CITY OF ALBUQUERQUE

August 24, 2012

**Re: Sevano Point Subdivision
Grading and Drainage Plan
Engineer's Stamp Date 07/31/2012 (C18/D075)**

Preliminary Plat

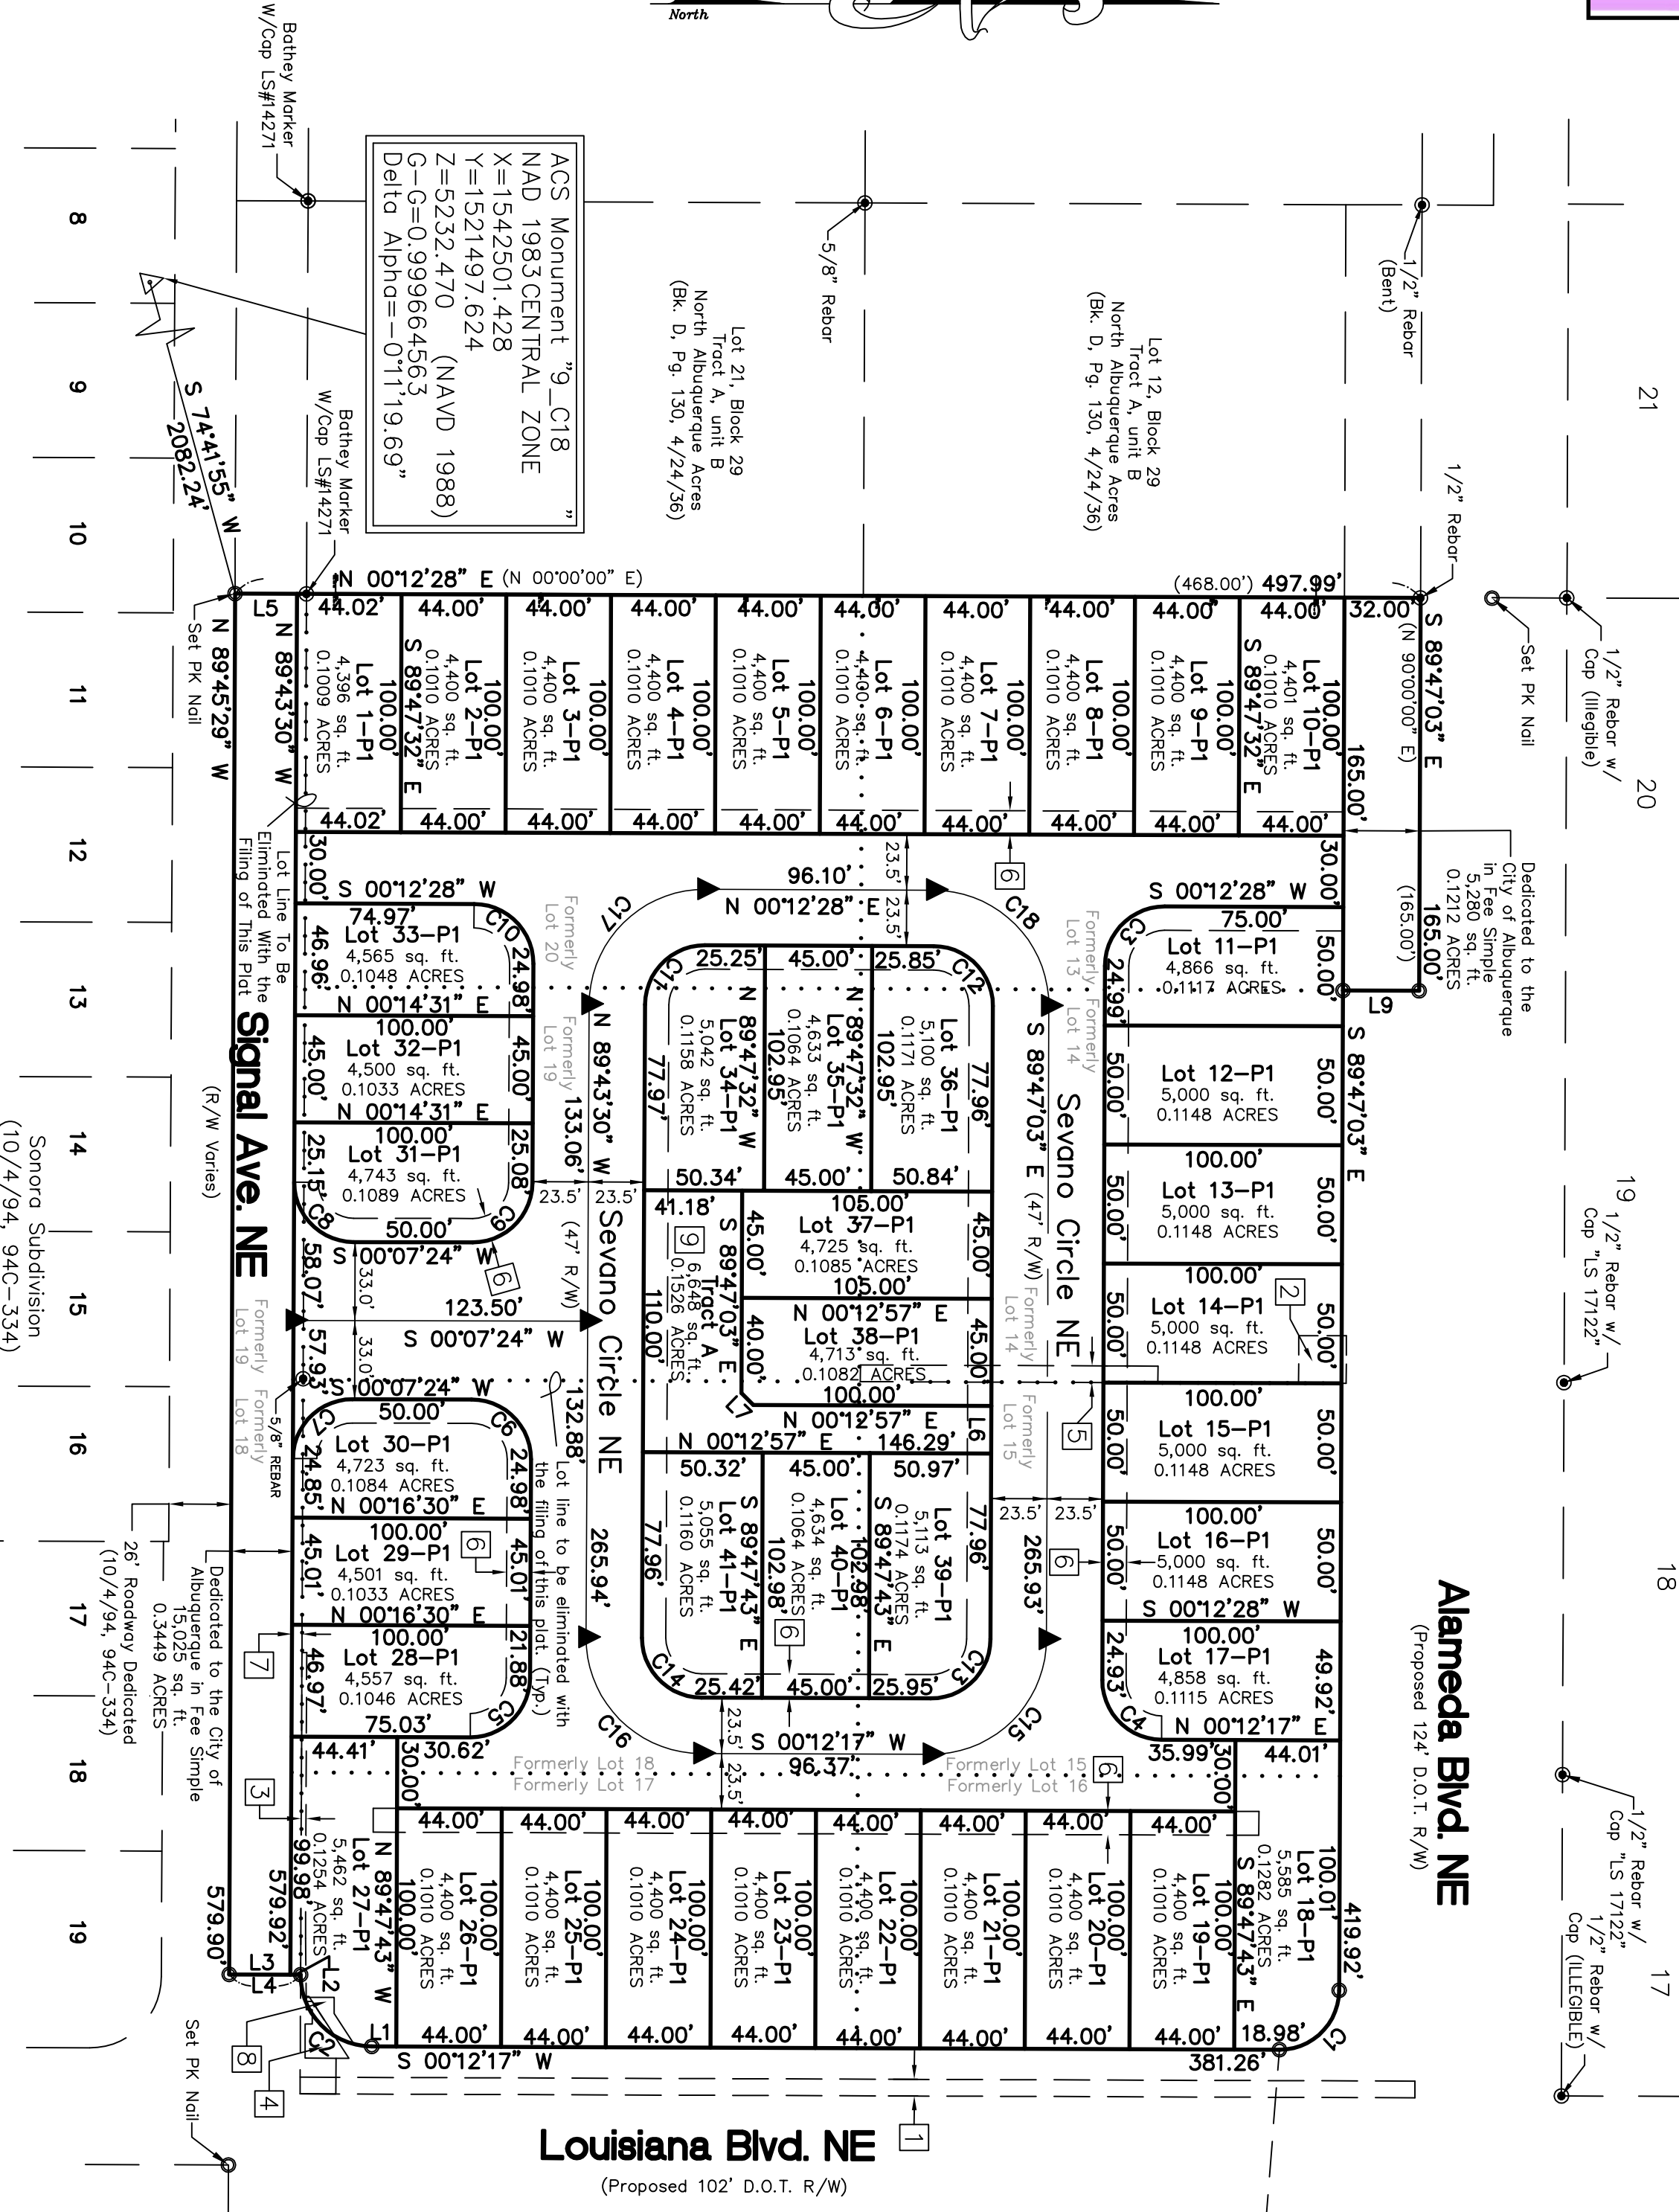
- Use the entrance to drain the southerly basin to Signal Avenue. We suggest that the entrance would be moved to the west.
- Please provide copies of the proposed plat and infrastructure list.

SIGNAL AVENUE PLAN

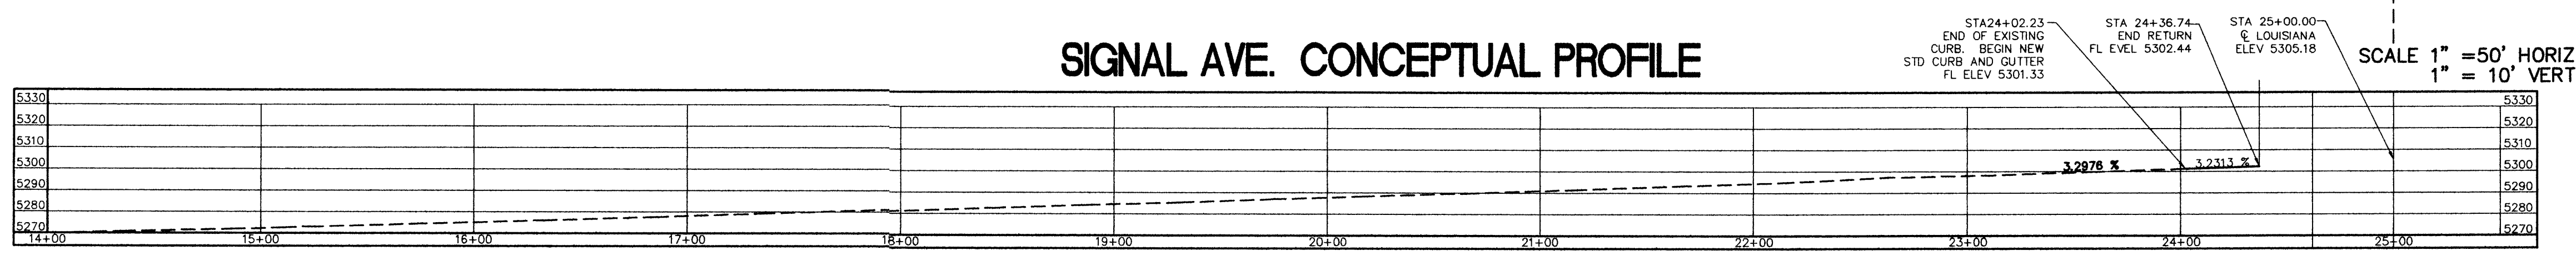
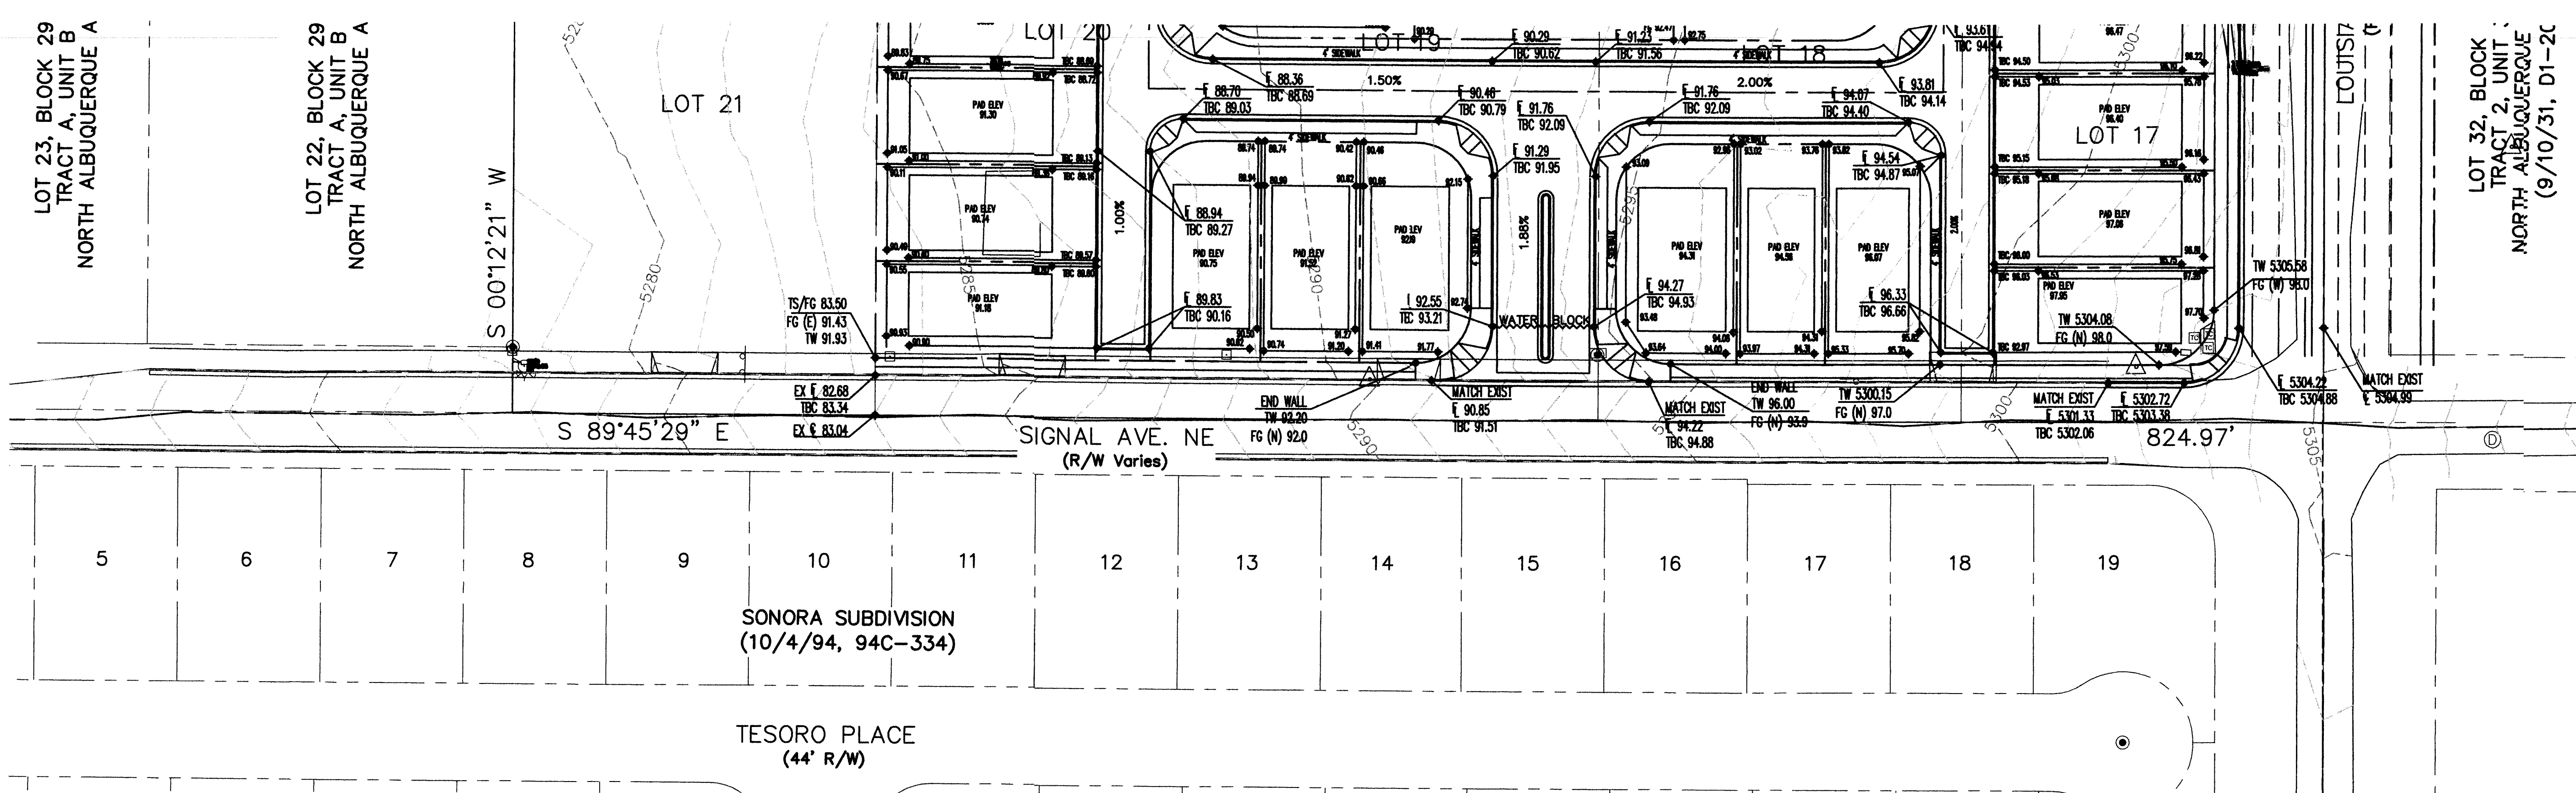
- Provide street flow capacity analysis for Signal Avenue. Where does the runoff drain to and does the storm drain system downstream has adequate capacity? You may have to construction drop inlets downstream to intercept the runoff.
